**SABIC UK PETROCHEMICALS  
TRANS-PENNINE ETHYLENE PIPELINE**

**Planning Application No 3/2021/0278, Ground mounted installation of  
solar array for energy generation  
Location: Dudland Hollins, Gisburn**

*Figure 2 - Panel Arrangement*

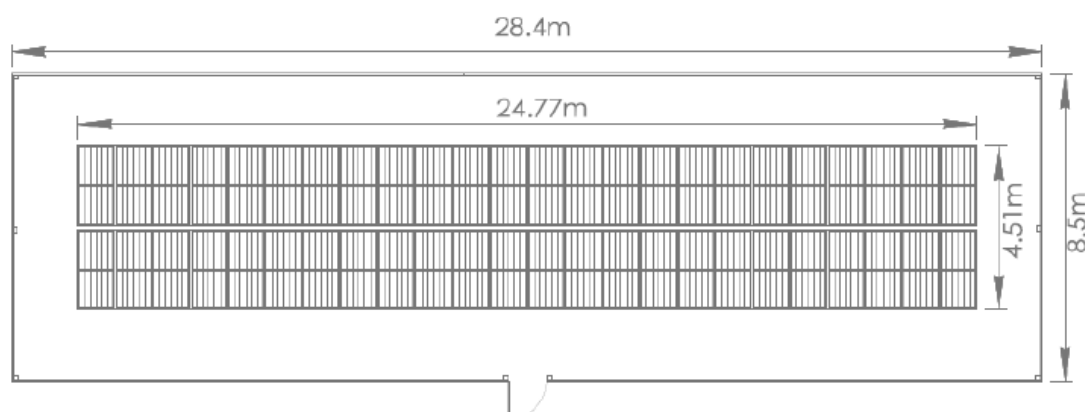
The proposed development is situated in the same parcel of land as the TPEP,  
and falls within the inner consultation zone of the above Major Accident  
Hazard Pipeline as defined by the HSE development control guidelines (PADHI  
– HSE's Land Use Planning Methodology document). I would advise that the  
fenced area is kept outside the pipeline 6m easement.

In terms of the safety and engineering integrity of the pipeline, the developer  
of the solar installation will need to submit their design drawings for approval.  
The areas of concern for SABIC are location of metallic structures / routing of  
electrical cables and the impact on land drainage schemes close to the  
pipeline.
